Our Ref: LU/89/22/NMA

Non material amendment following the grant of LU/168/21/HH for change of hipped to gable end at rear of single storey extension, change of external boarding colour and lowering underside of boarding to ground floor window cill level.

12 Reef Close Littlehampton BN17 6QG

Drawing P01a May 2021 Scale 1:100 / 1:500 @ A3
Planning Drawing - Ground Floor & Block Plan & Elevations

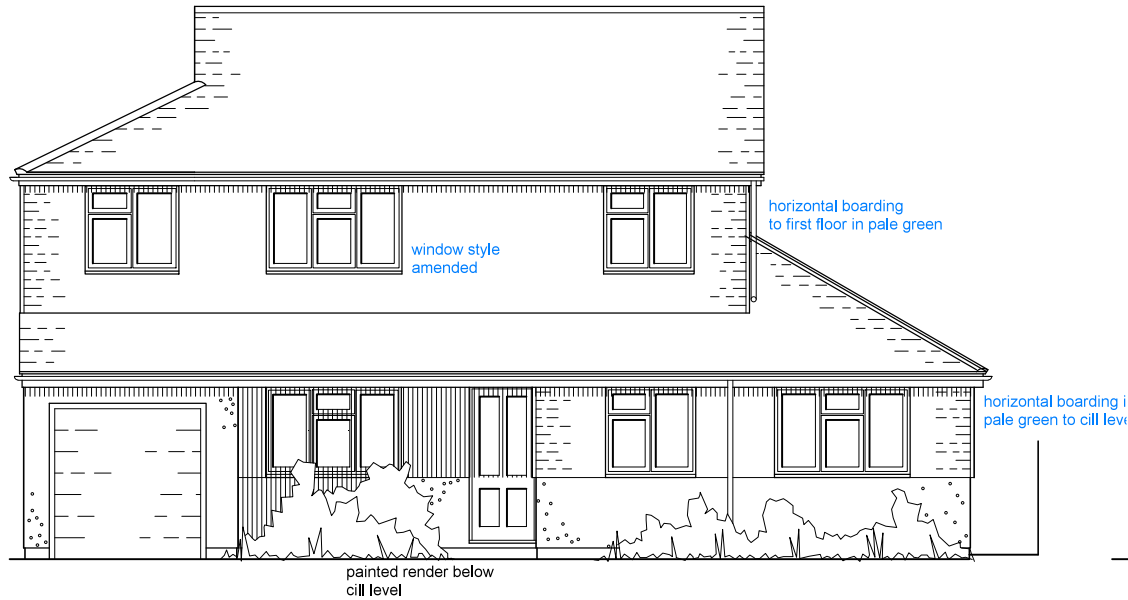
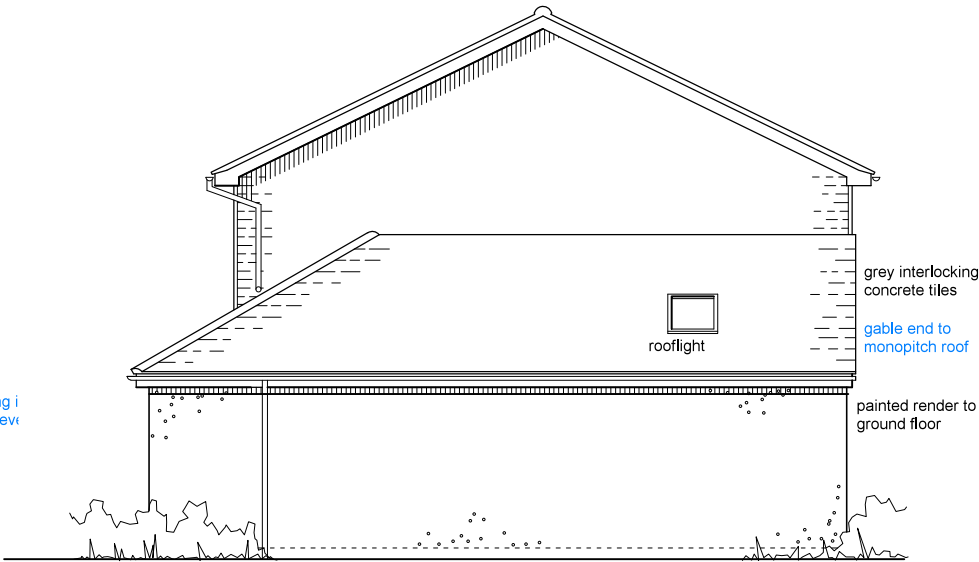
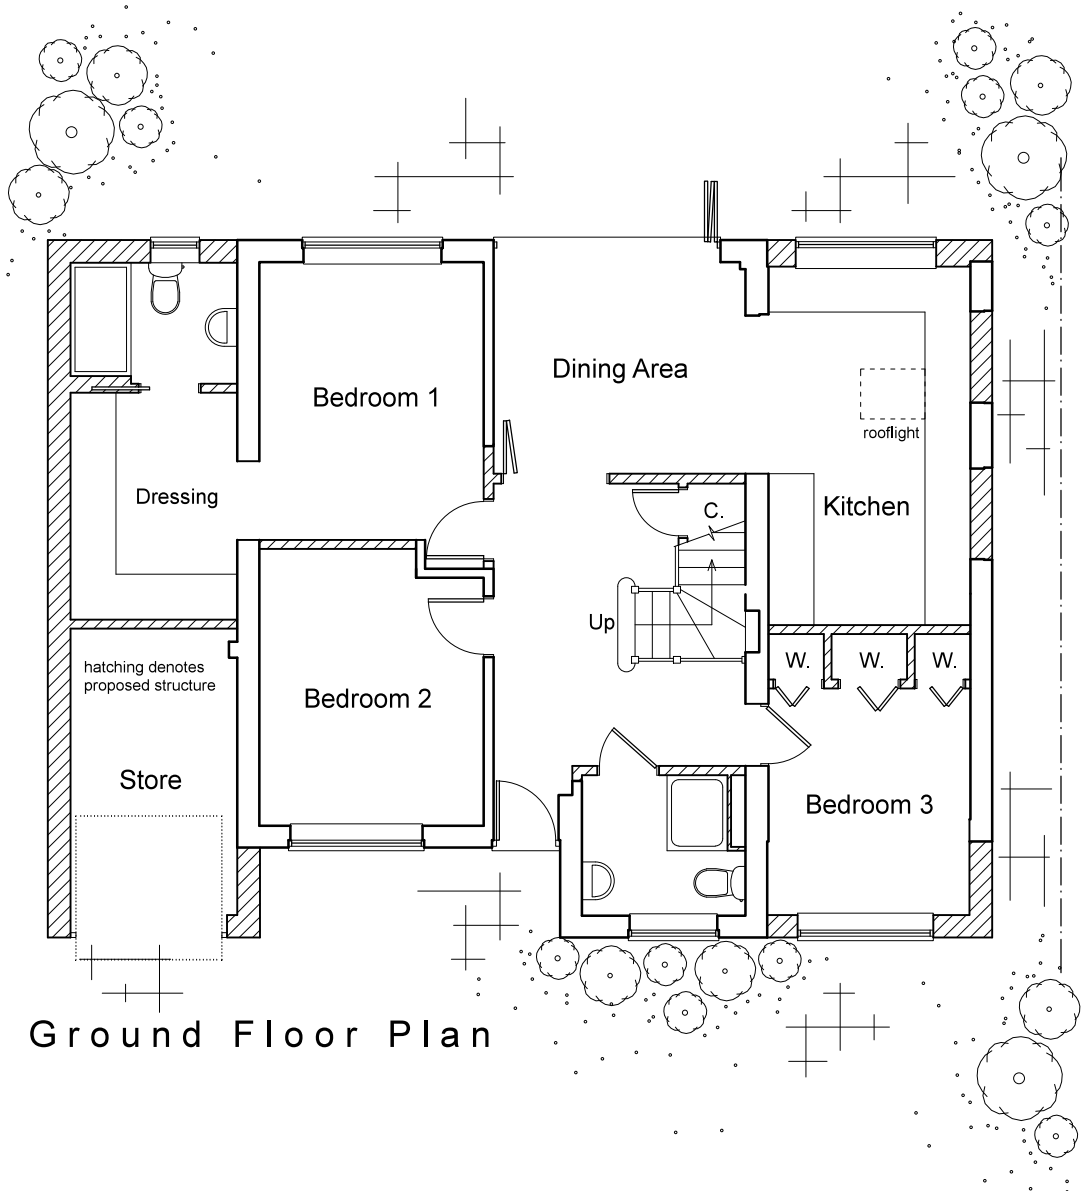
The reasons that these proposals have not been accepted as Non-Material Amendments is because the hip to gable alteration and increase in coverage of the approved cladding would materially alter the external appearance of the building and the change of coloration to pale green cladding would also contradict condition 3 of the application, stating that the building hereby permitted shall match in colour and texture those of the existing building. Therefore, it cannot be considered under section 96A of the Town and Country Planning Act 1990.
